The Coal
Authority

8th February 2024

Re: 2021/1090 - Hybrid application for residential development for 1,560 dwellings comprising: a) Full planning permission for: earthworks to create development platforms; strategic drainage ponds/dry detention basins and associated drainage infrastructure; construction of a new link road; location of strategic landscaping and ecological areas; demolition of existing buildings; works to Hermit Lane; and erection of Phase 1(a) residential development comprising 216 dwellings, b) Outline planning permission for: Residential development comprising up to 1,344 dwellings; new primary school; small shops and community facilities; and associated infrastructure works, (Amended Description and Amended Plans) - Land South of Barugh Green Road and East of Higham Common Road, Barnsley (Residential)

DRAWING TITLE
DEVELOPMENT MASTERPLAN & COAL MINING FEATURES

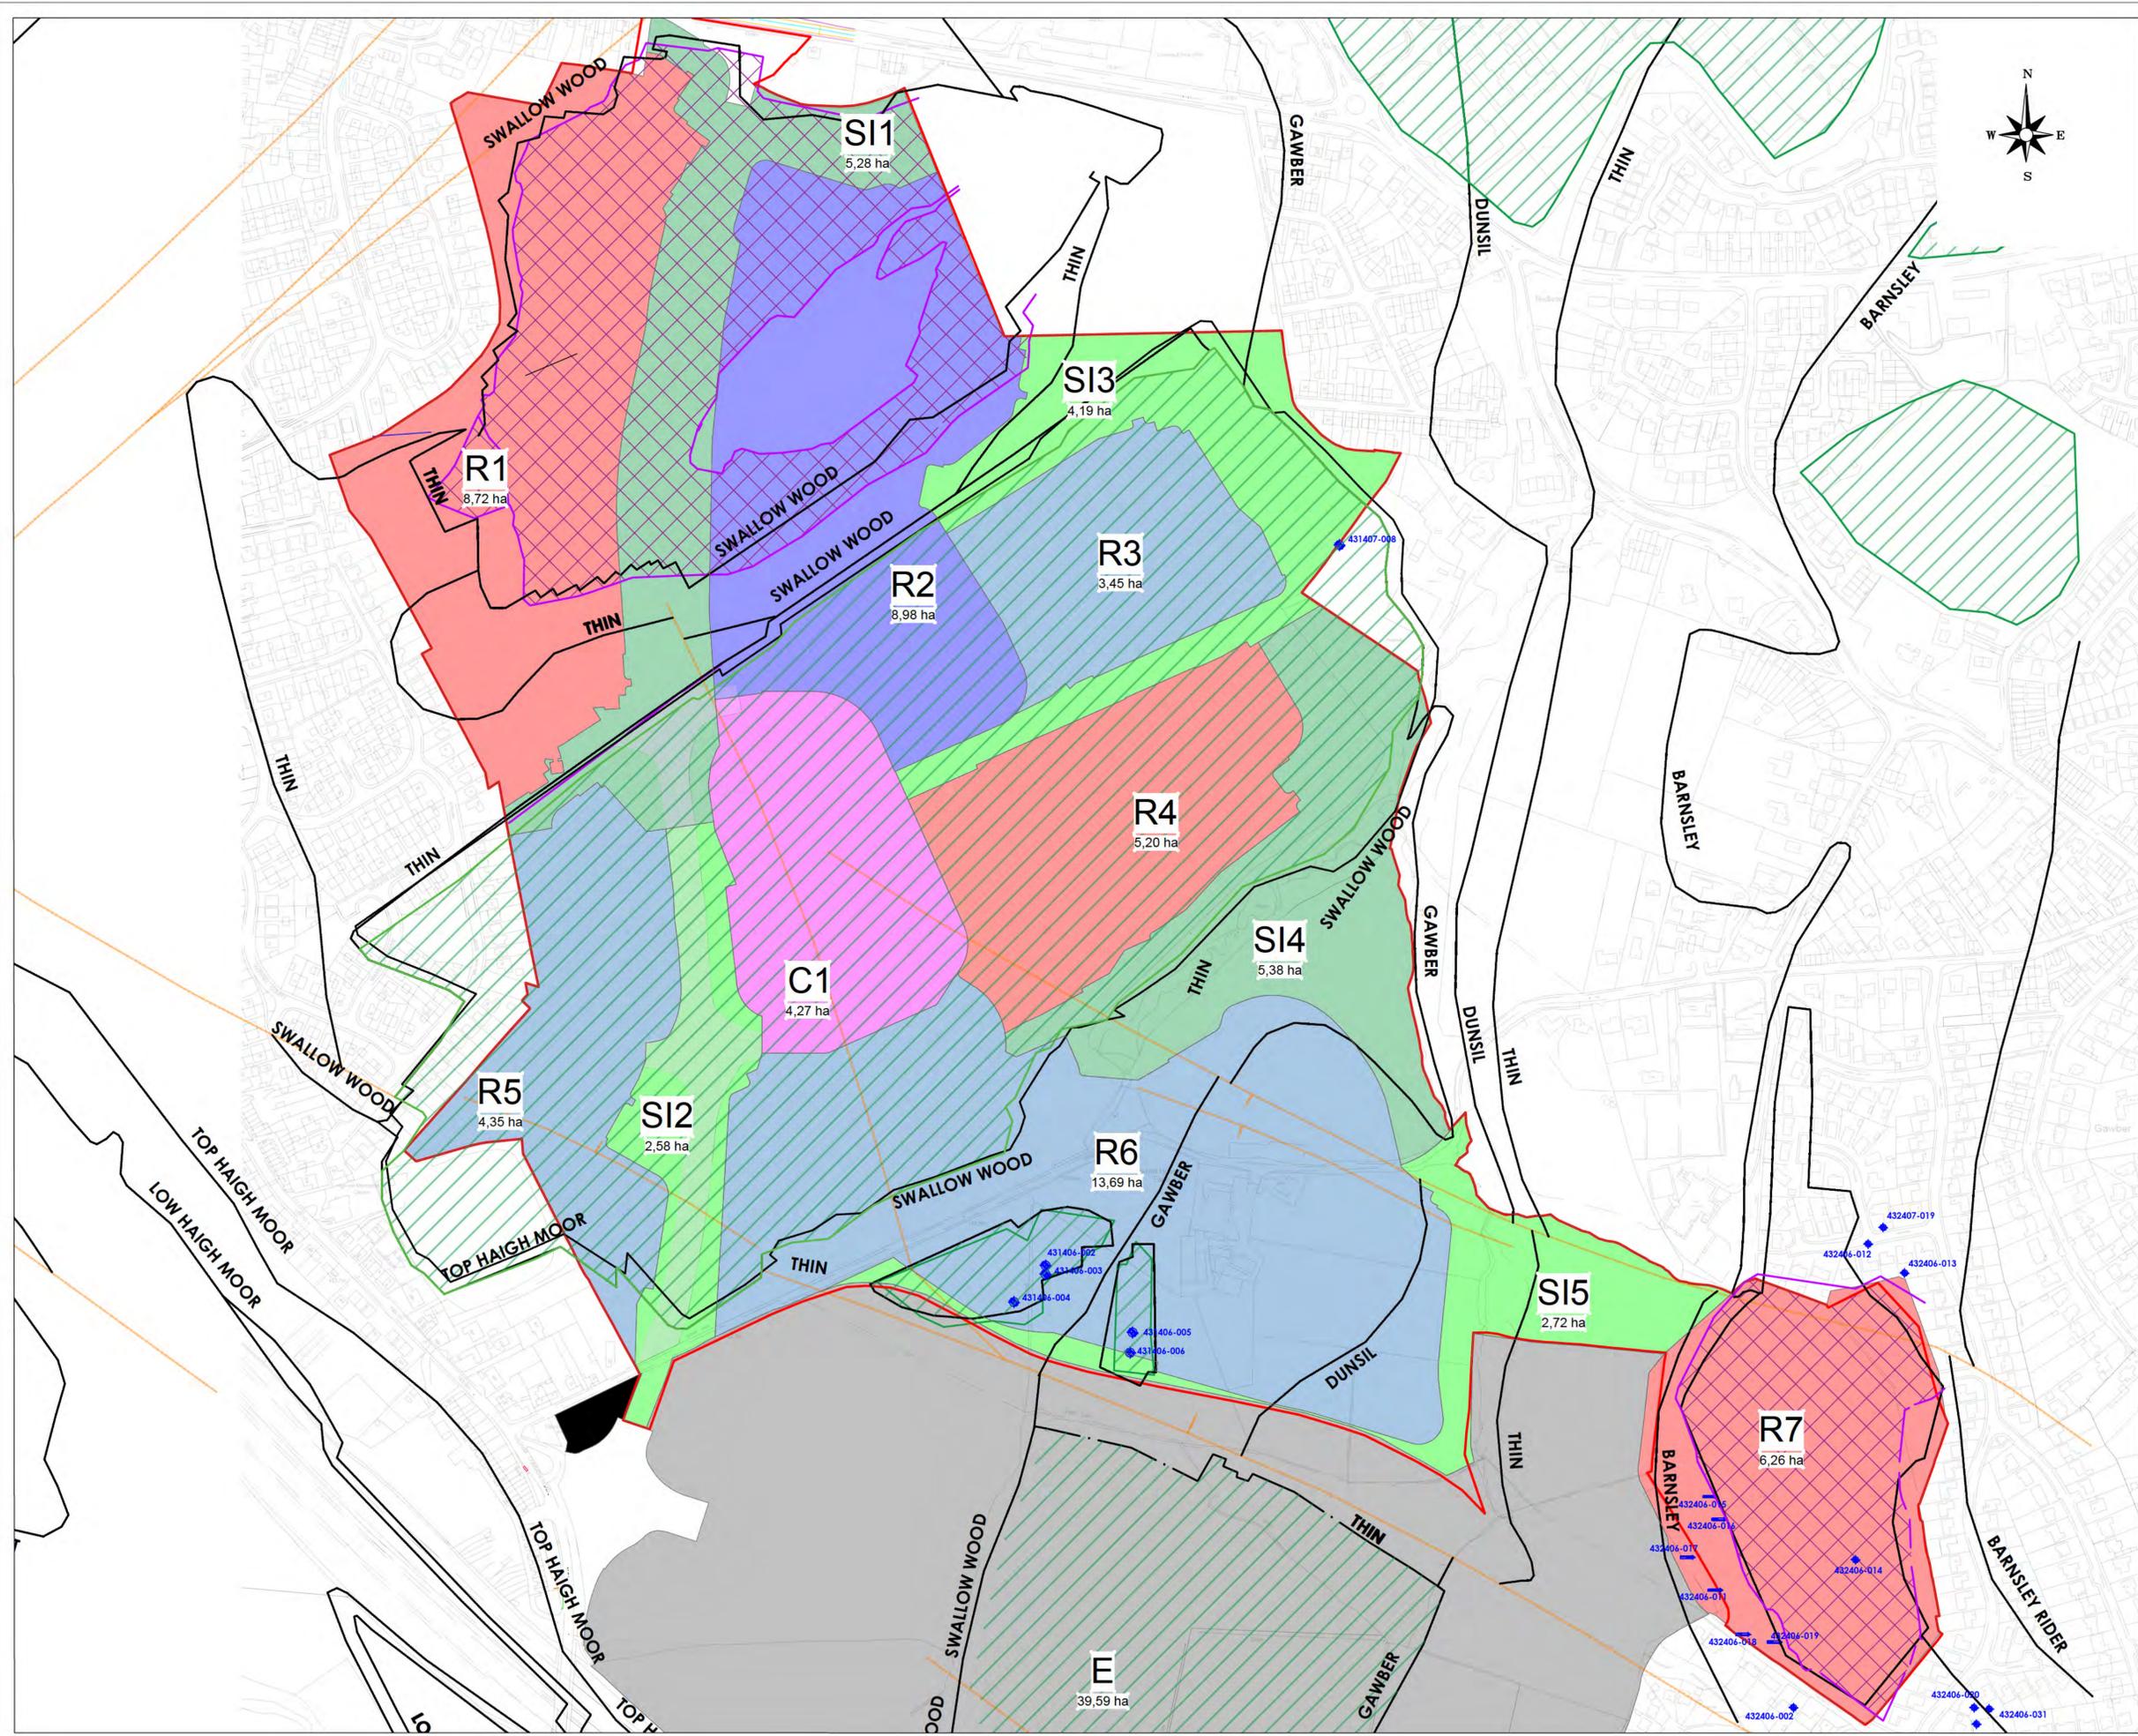
We have now been provided with a Preliminary Geoenvironmental Investigation Report, dated January 2024, and prepared by Lithos. This report covers plot Land Transfer 2 (LT2). My understanding is that this plot is being considered in outline. This report acknowledges that shallow mine workings may be present beneath the site and therefore recommends that intrusive site investigations are carried out to establish the exact situation in this regard. The report authors also make recommendations in respect of investigations to locate the surface mining high wall. Where this feature is present we would advise that layouts are designed to avoid buildings straddling this structure in order to avoid risks posed by differential settlement.

The report authors note the 6 mine entries are recorded to be present on site. They conclude that it is highly likely that these features have been removed as part of the surface mining activity. I have liaised further with my colleagues in the Mining Information team and they have now confirmed deletion of mine entries 431306-002 to 431406-006, leaving only mine entry 432407-008 in this area. We would expect the presence of this feature to be investigated and its risks posed to the development established. It is noted that this feature appears to be in an area of open space and not close to any built development in the masterplan.
